Rezoning Petition Review

Rezoning Petition #: 20-88

Location of Property: Approximately 49.79 acres located along the northeast side of Prosperity Church Rd and the south side of Johnston Oehler Rd.

PCR MIXED USE
 PREPARED FOR
WSB RETAIL
 CITY OF CHARLOTTE, NC
 SHEET NUMBER
RZ-1

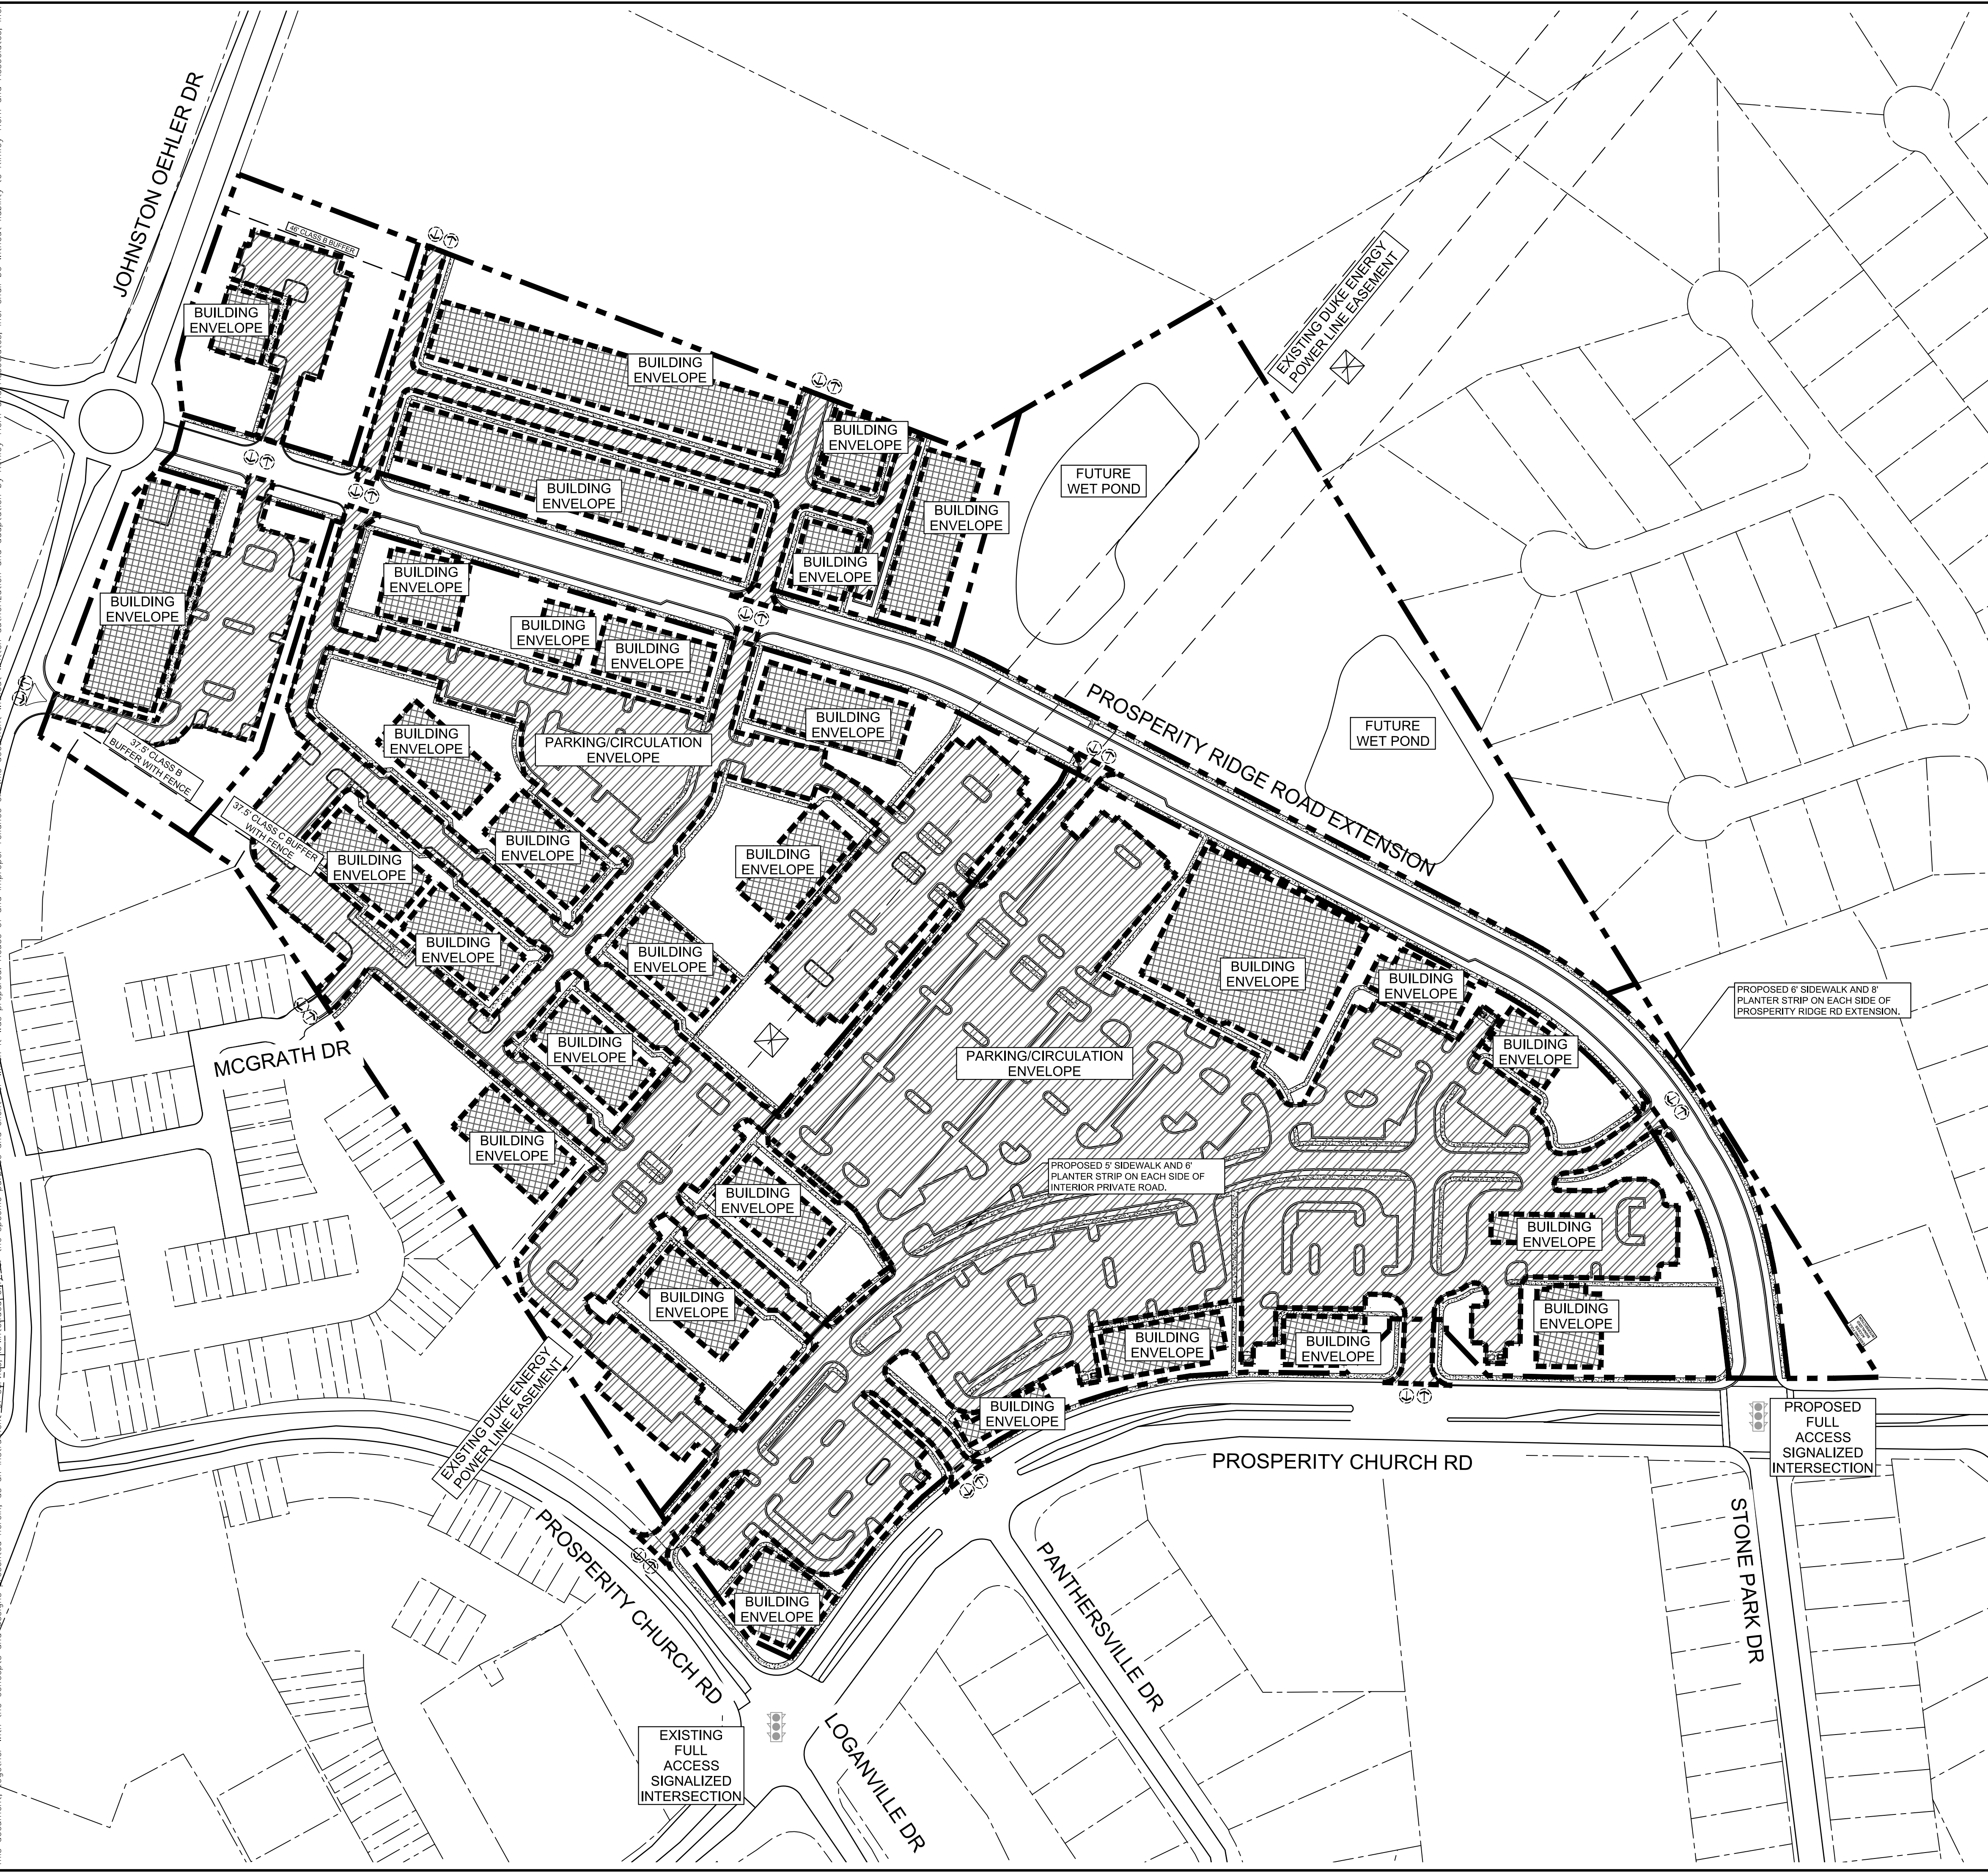
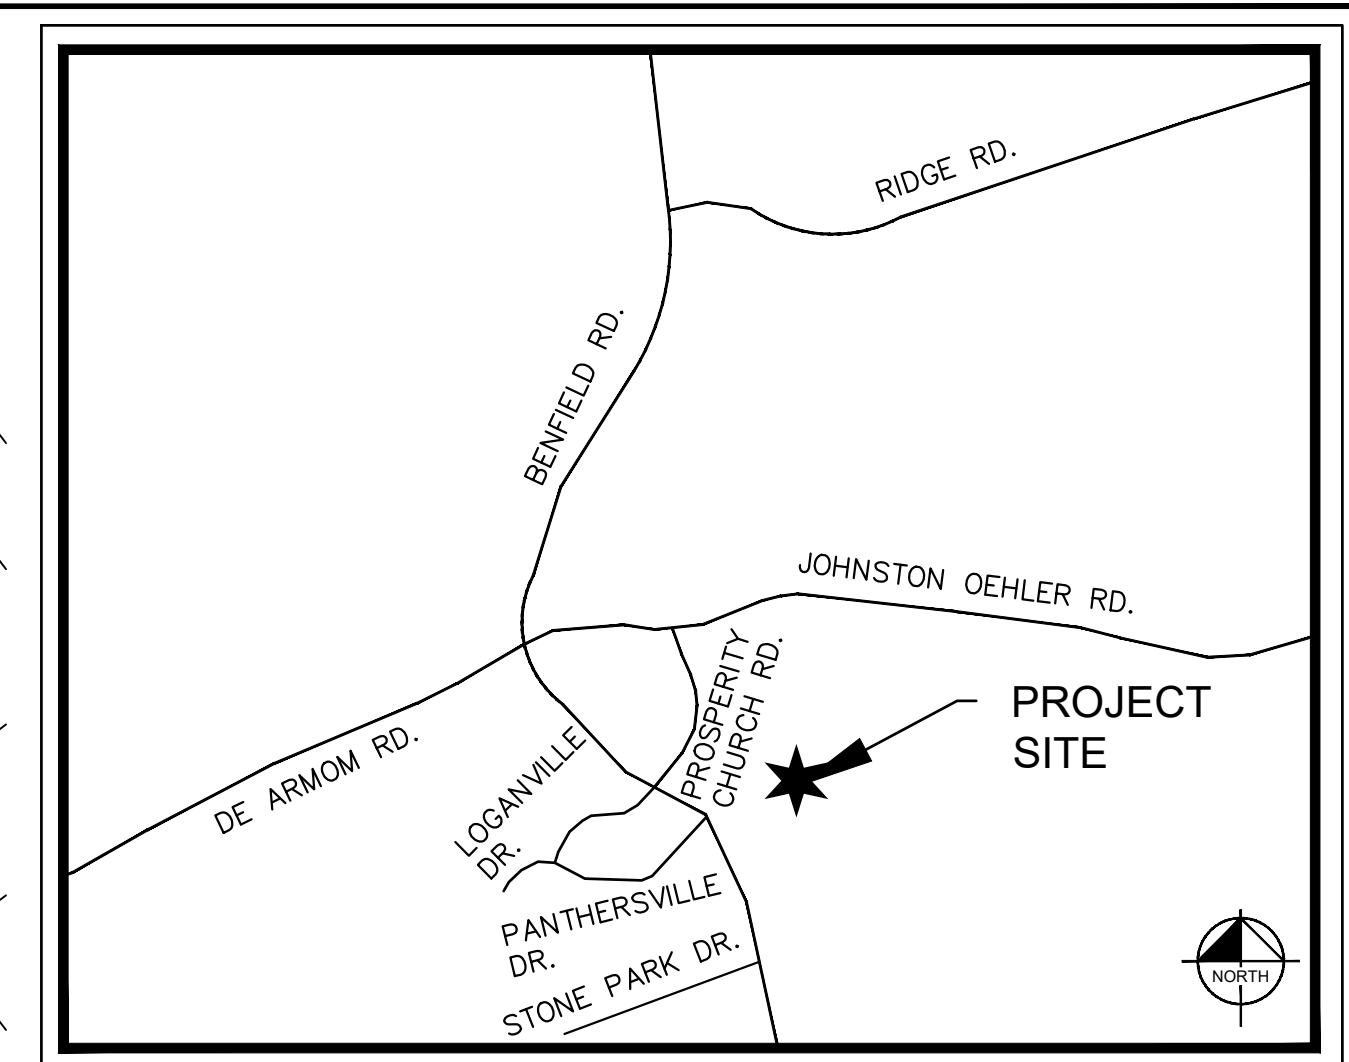
Recommendations Concerning Storm Water: City of Charlotte GIS data indicates a 50-ft Undisturbed PCSO buffer and a 100-ft Undisturbed PCSO buffer across the site. Please show and label these buffers on the site plans. Any increase of impervious area within such buffers may not be allowed and is not approved with the rezoning process. Stream Delineation Reports are subject to review and approval by Charlotte Storm Water Services. Please include the following note under Environmental Features: *“Development within any SWIM/PCSO Buffer shall be coordinated with and subject to approval by Charlotte-Mecklenburg Storm Water Services and mitigated if required by City ordinance.”*
